Your Ref: OWPC18015
Our Ref: P/25/18/PL 06-03-2018
Please ask for:
Andrew Wood

Demolition of existing garage, roof alterations to existing dwelling to provide first floor &
1 No. new dwelling in garden of existing dwelling.

Jenin Nyetimber Lane Pagham

Job Title	Nyeinmber Lane	
Drawing Title	Proposed Elevations	
Client	R.B	
Date	12/05/2017	
Drawn	P.J.G	
Scale	1:100 on A3	
Drq No.	NTL/E/01

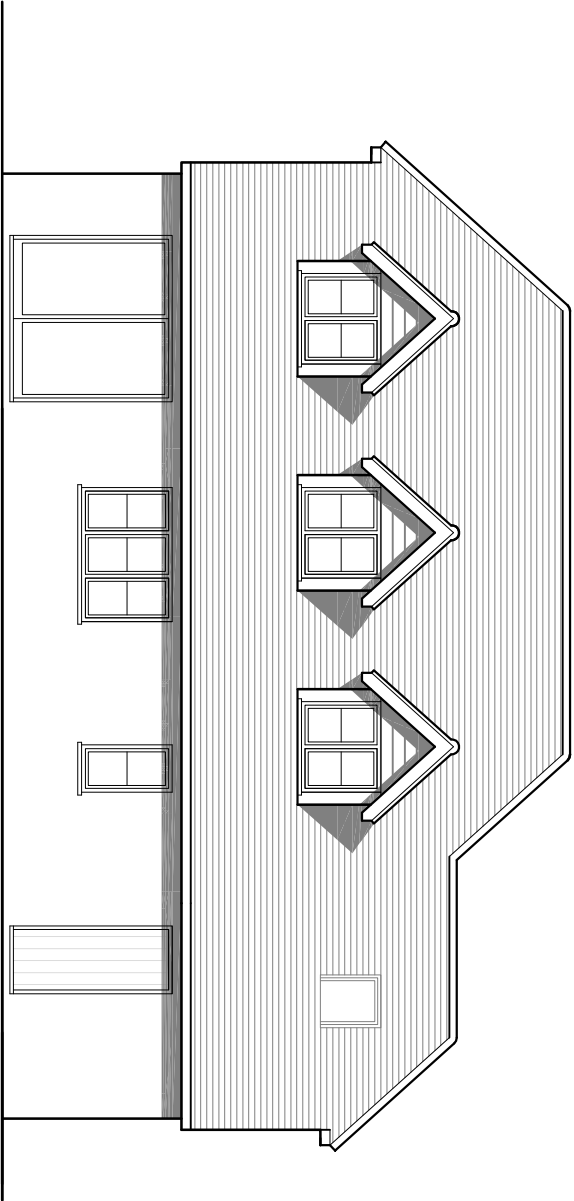
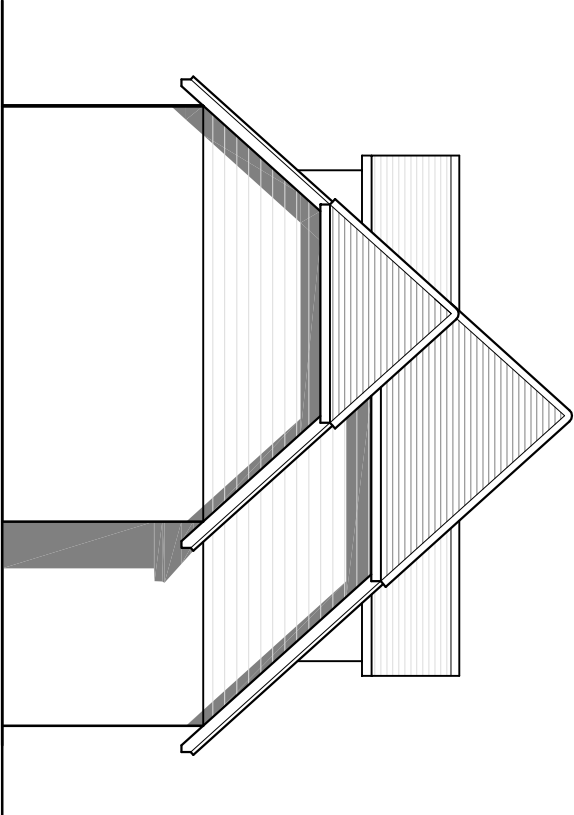
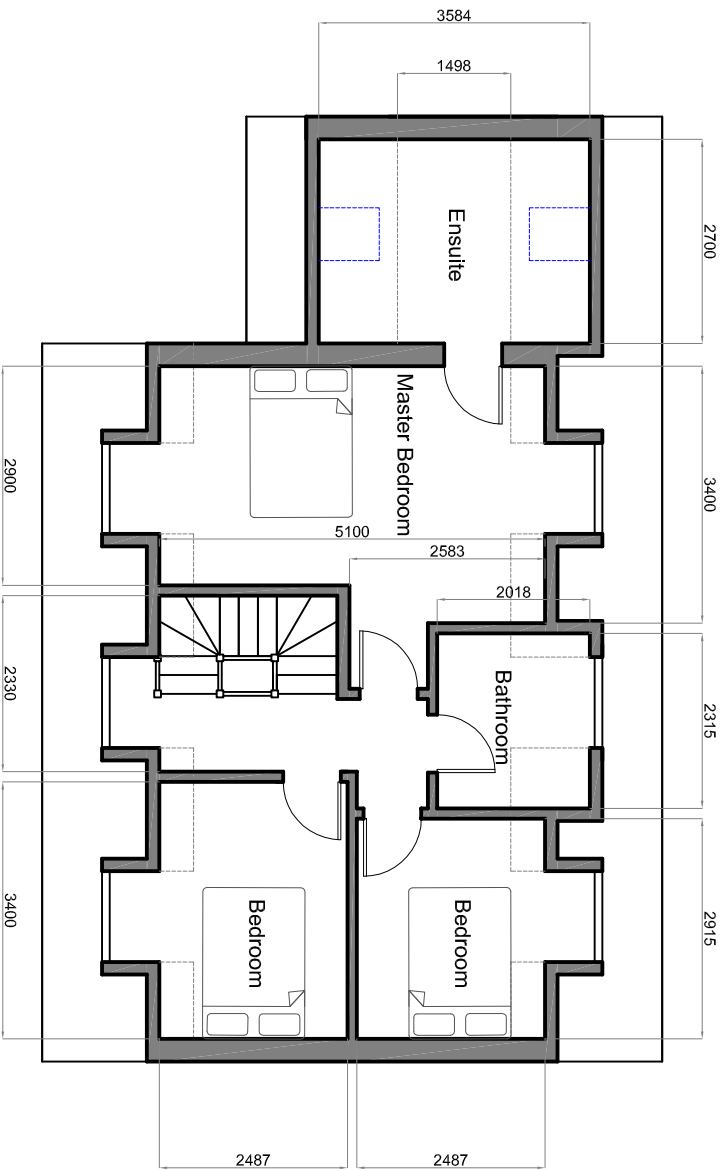
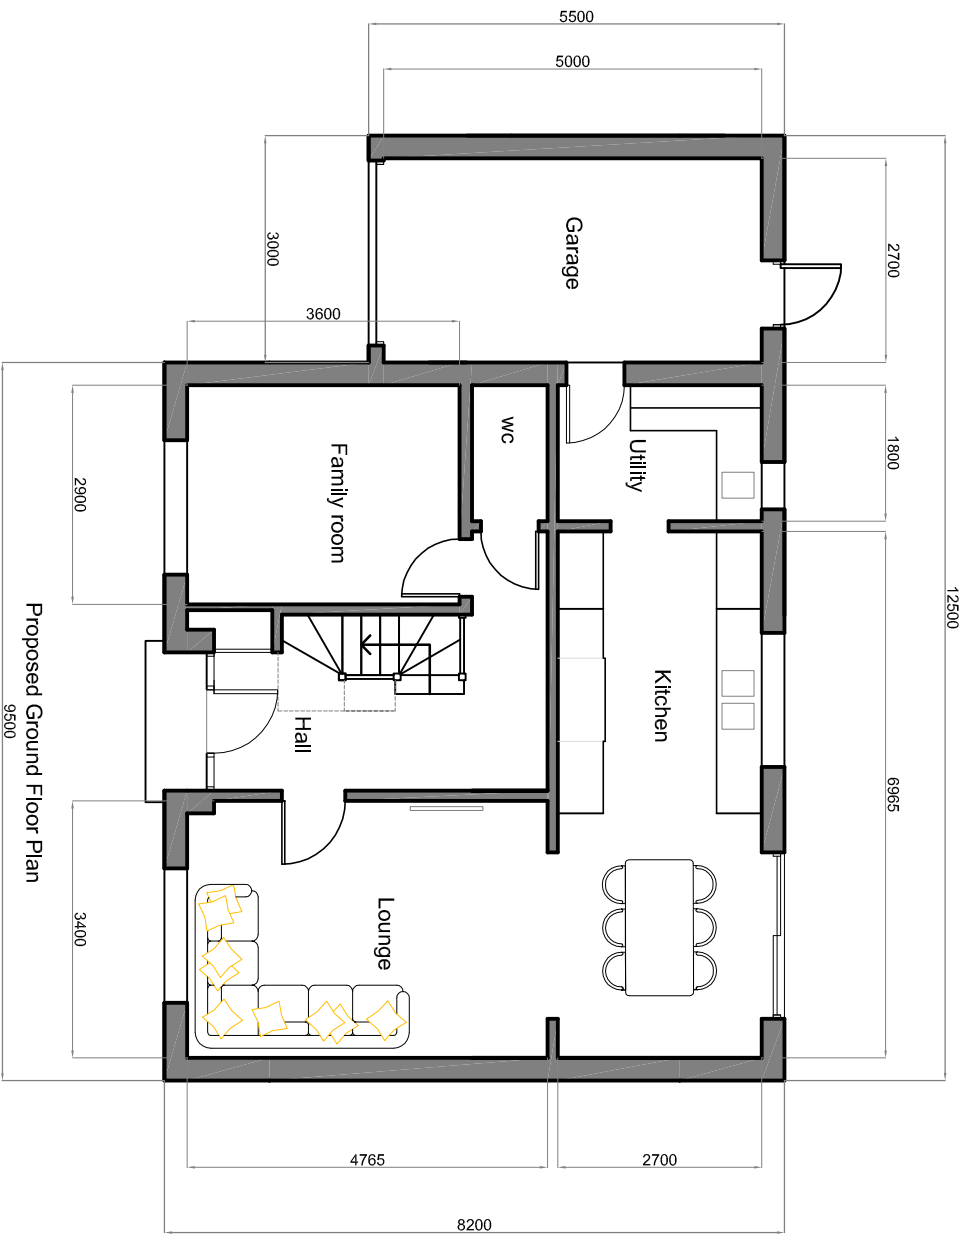
*Have great concern as to the proposed/planning application for a two story dwelling in the
garden of Jenin Nyetimber Lane, which is adjacent to our property, We are not too
concerned with
the original property being provided with with a first floor, as it is within our building line,
but the
proposed new dwelling added to the garden will be very overpowering and obtrusive.
We purchased Sportsview About six months ago(for a considerable amount of monies)
because we liked its position and outlook, we think two dwellings side by side, right next to
us will definitely
encroach upon us so much that our property will be devalued. This means we will be
boxed in the whole North West side of our garden.
Needless to say we are very much apposed to building permission being granted.*
